Application Reference: 2025/0436

Site Address: 95 Strafford Avenue, Elsecar, Barnsley, S74 8AL

Introduction: Erection of 2 sheds to use as workshop and games room.

NG= NEW GAMES ROOM. SCALE 1:50 ELEVATIONS

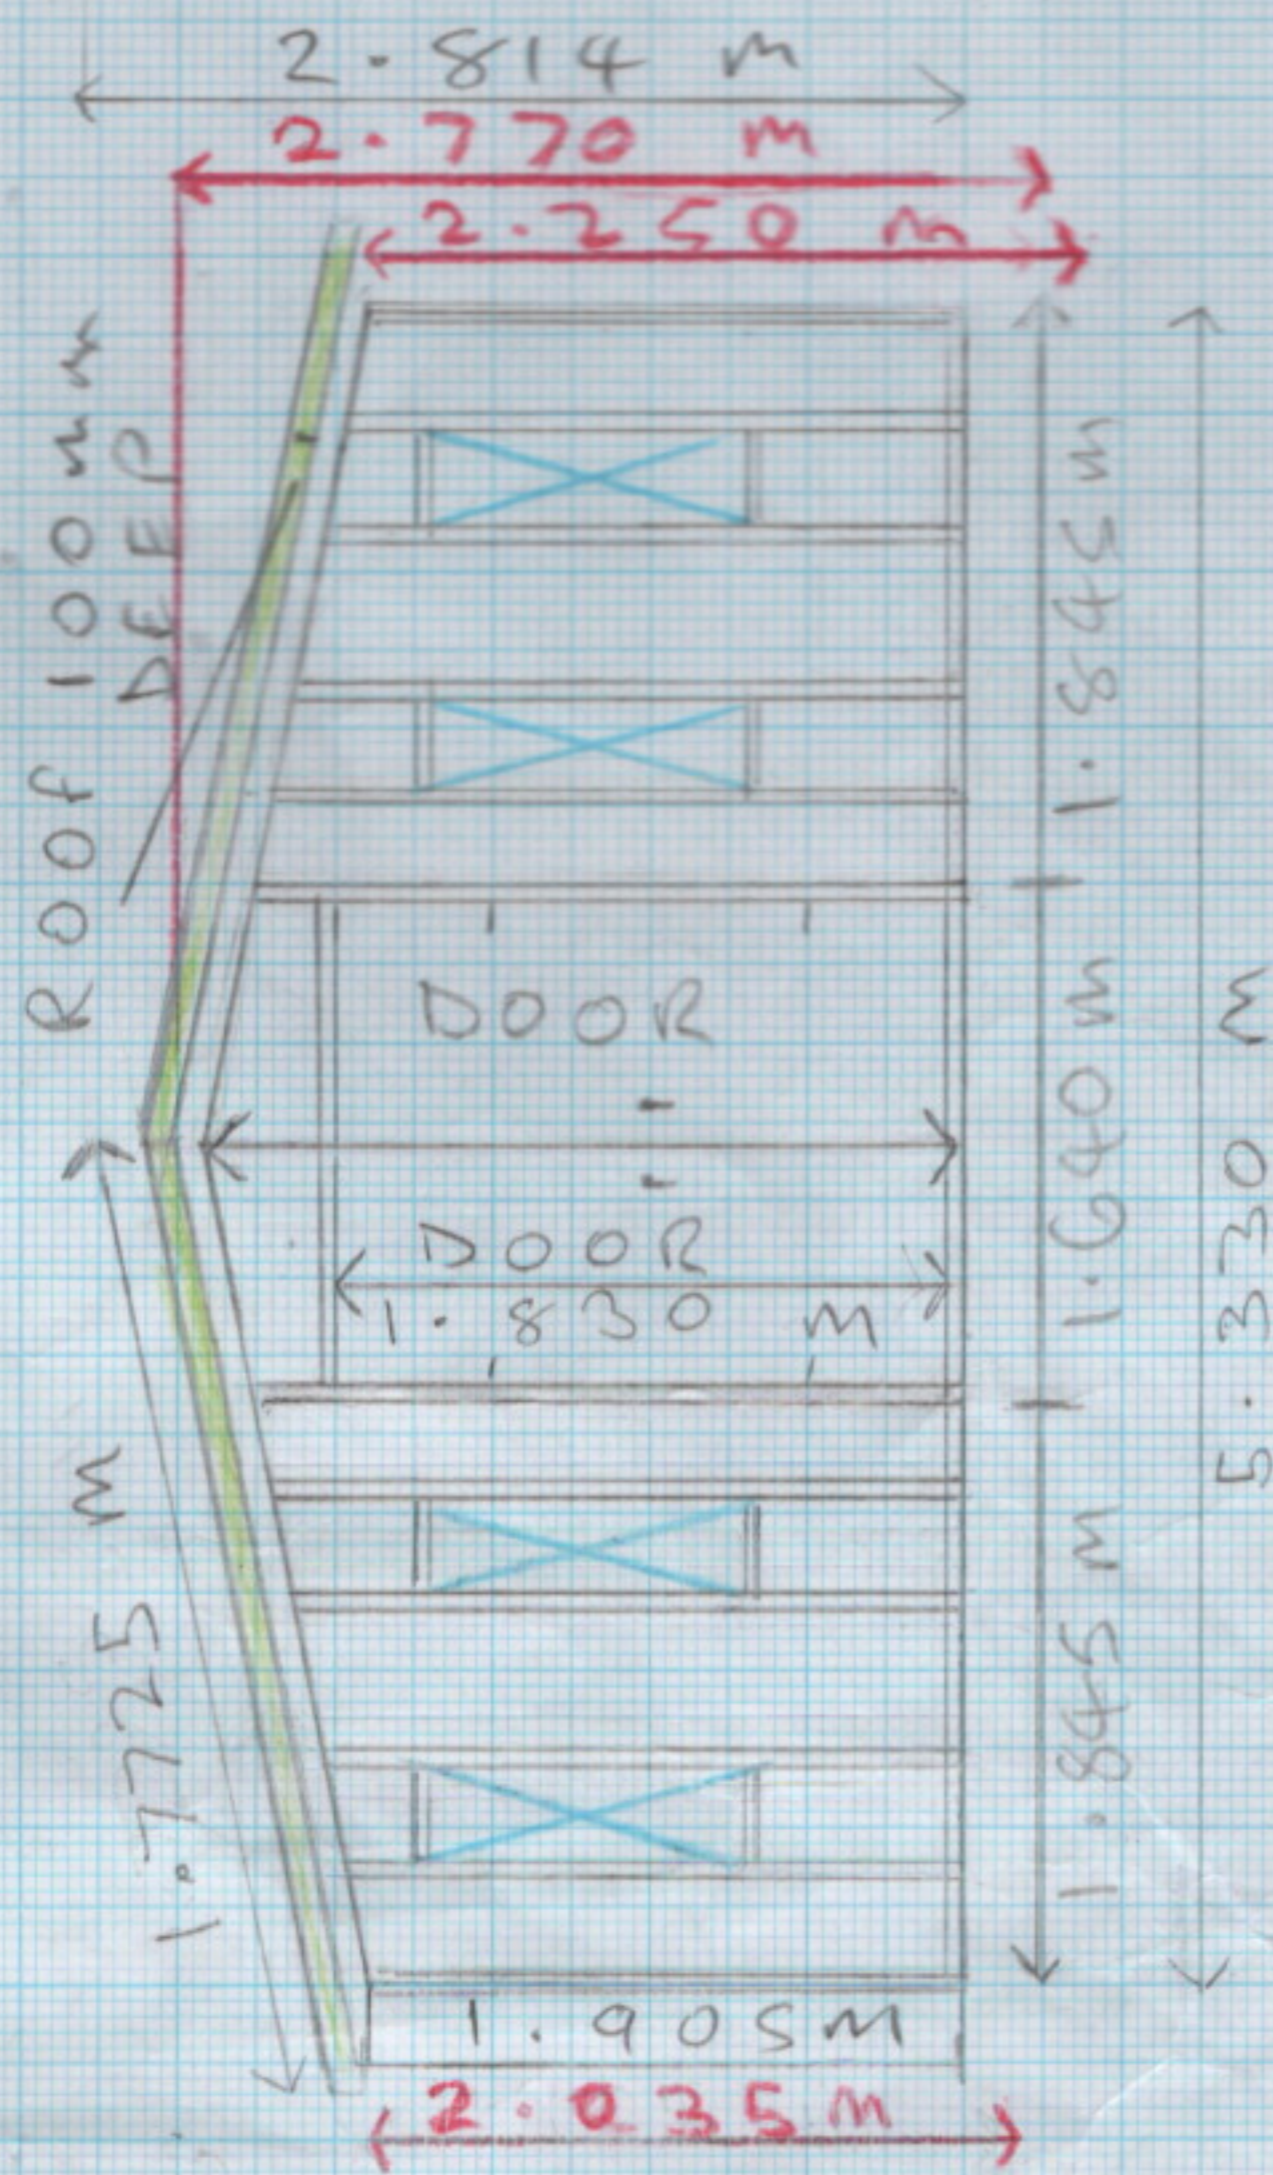
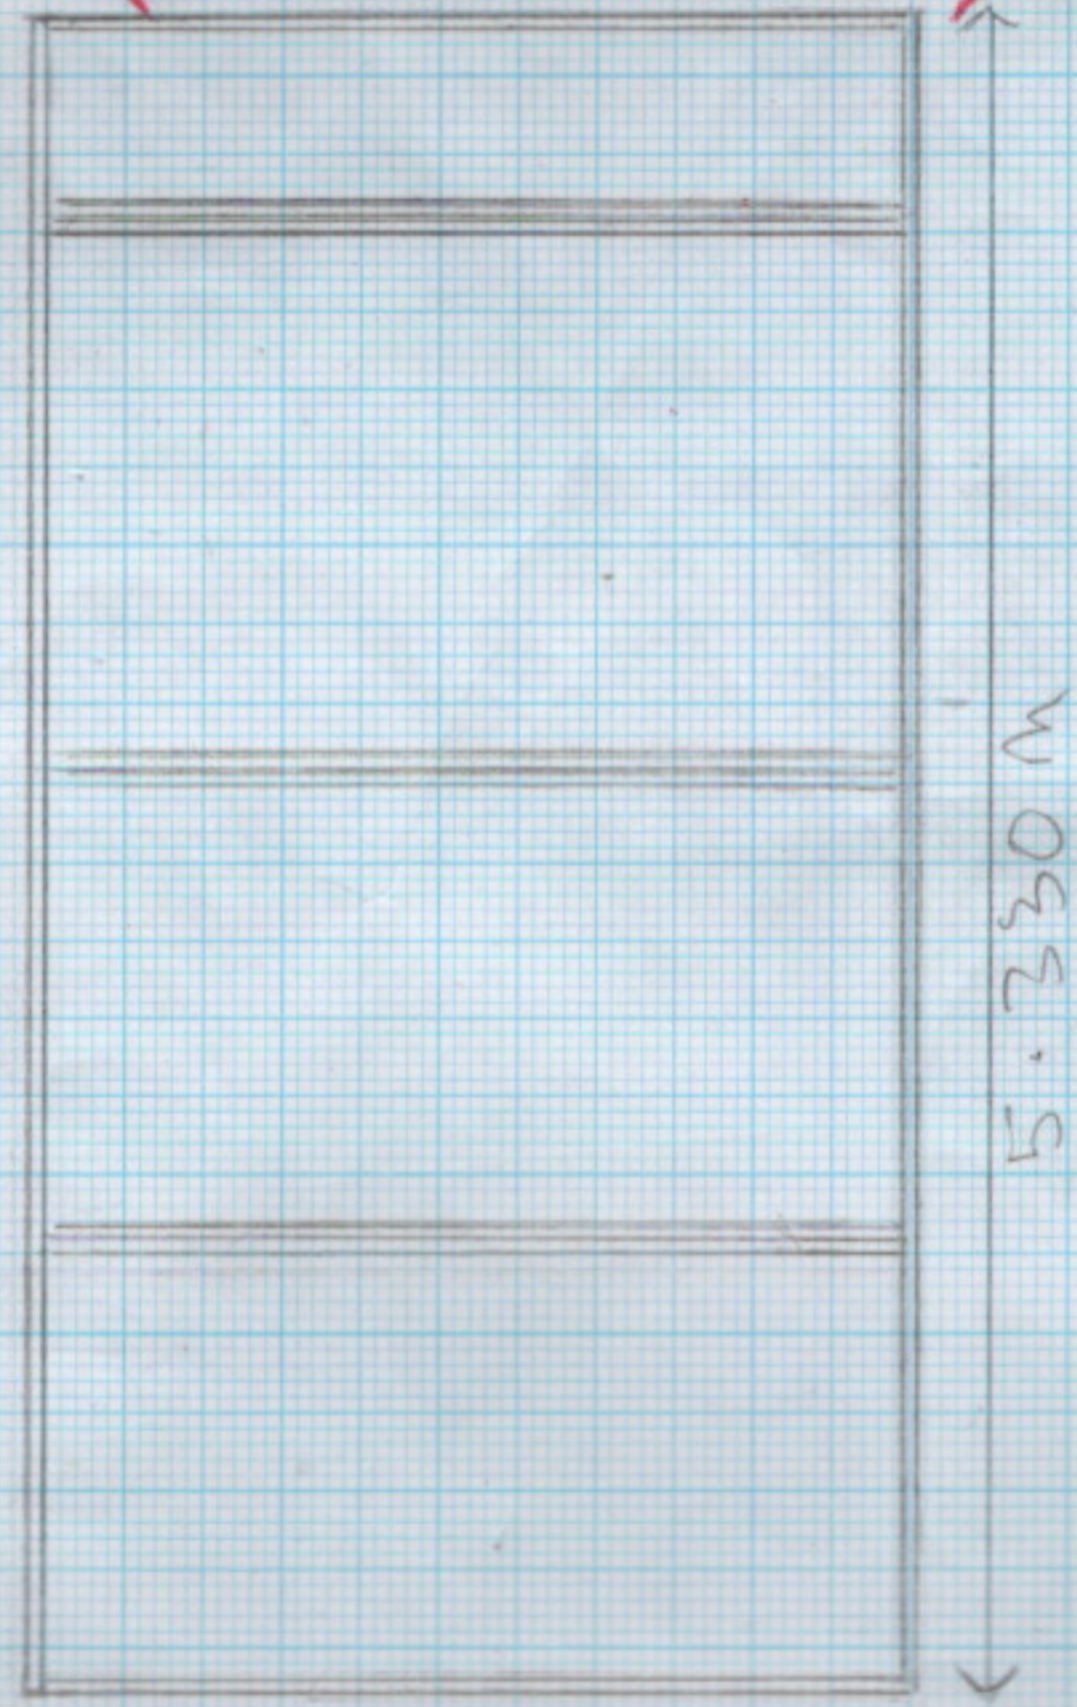
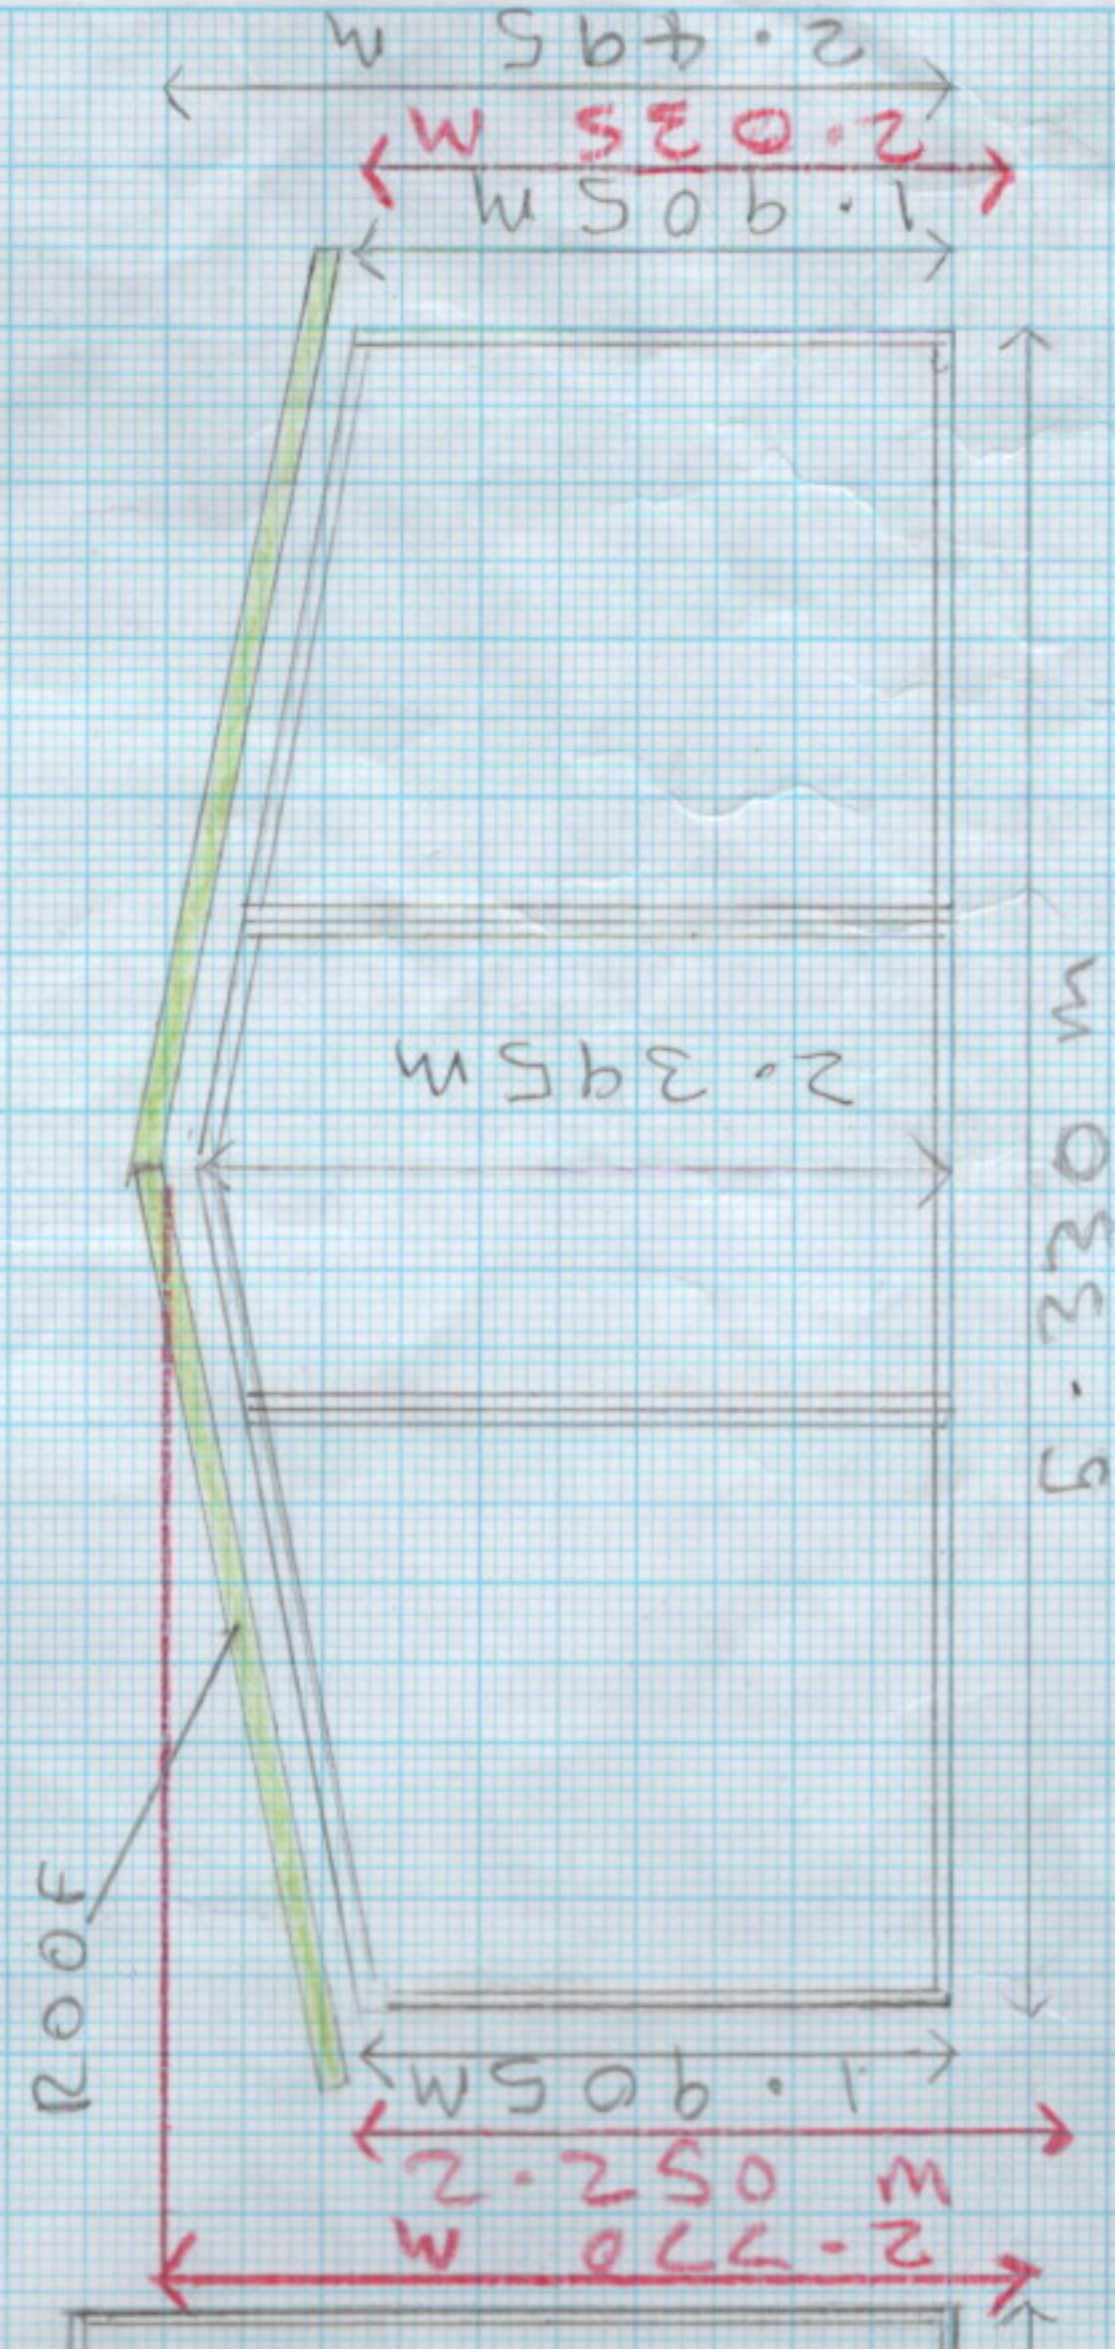
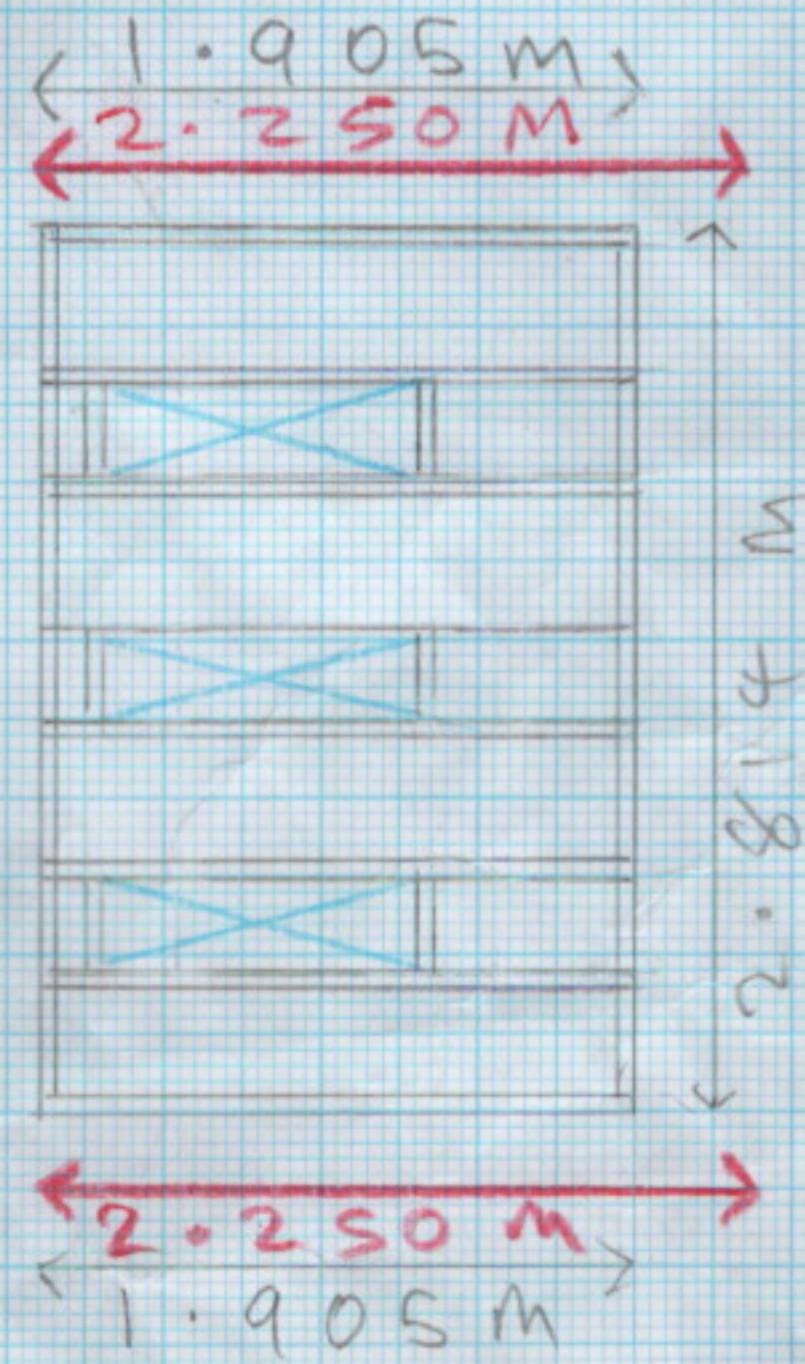
The New Games Room would have an approximate floor space of 14.9 square metres, an approximate roof height of 2.77 metres and an approximate eaves height of 2.25 metres. A pitched roof has been detailed. Four elongated windows are detailed to the east elevation of the outbuilding, two either side of the proposed doors spanning 1.64 metres. Three elongated windows are detailed the north side elevation and three to the south side elevation. The outbuilding would be constructed from timber.

The proposed two proposed outbuildings would be erected within close proximity to the neighbouring boundary to the west. The size and scale of the outbuildings are not likely to cause any issues in terms of loss of light or outlook. The height of approximately 2.77 metres is less than the maximum 4 metres for outbuildings as outlined within the House Extensions SPD and the eaves heights of approximately 2.26 and 2.26 metres is also less than the maximum eaves height of 2.5 metres. These heights are not significantly greater than the existing boundary treatment and would not be impactful enough to cause detrimental harm to loss of outlook and sunlight.

The proposed new outbuildings are detailed to a scale in line with the House Extensions SPD. The height of approximately 2.77 metres is less than the maximum 4 metres outlined within the House Extensions SPD and the eaves heights of approximately 2.26 and 2.26 metres is also less than the maximum eaves height of 2.5 metres. The use of wood materials does not match the material of the site dwelling, however wooden sheds are common feature of residential gardens and are not considered detrimental to the character of the site, especially given they cannot be seen from the street scene.

The addition of the proposed new outbuildings would increase the cumulative floor space to approximately 81 square metres, approximately 69% of the total curtilage. Given the accumulation of the floor space taken up by the existing outbuildings and the proposed new outbuildings, it is considered the development at the site to be excessive and to take up a disproportionate amount of private rear garden space. It is acknowledged the erection of the two proposed outbuildings has begun but is not yet completed.

It has been necessary to make contact with the applicant to request plans and elevation of the proposed New Workshop and New Games Room in order to obtain more accurate roof and eaves heights for accurate assessment of the proposal. This information was provided and resulted in amended plans and elevations.

In the opinion of the local planning authority, the cumulative impact of the erection of two new outbuildings for use as a workshop and games room alongside several existing outbuildings would result in a disproportionate amount of the rear garden being developed. The cumulative impact of the existing and new development would also have an overtly dominant impact on the character of the application dwelling to the detriment of visual
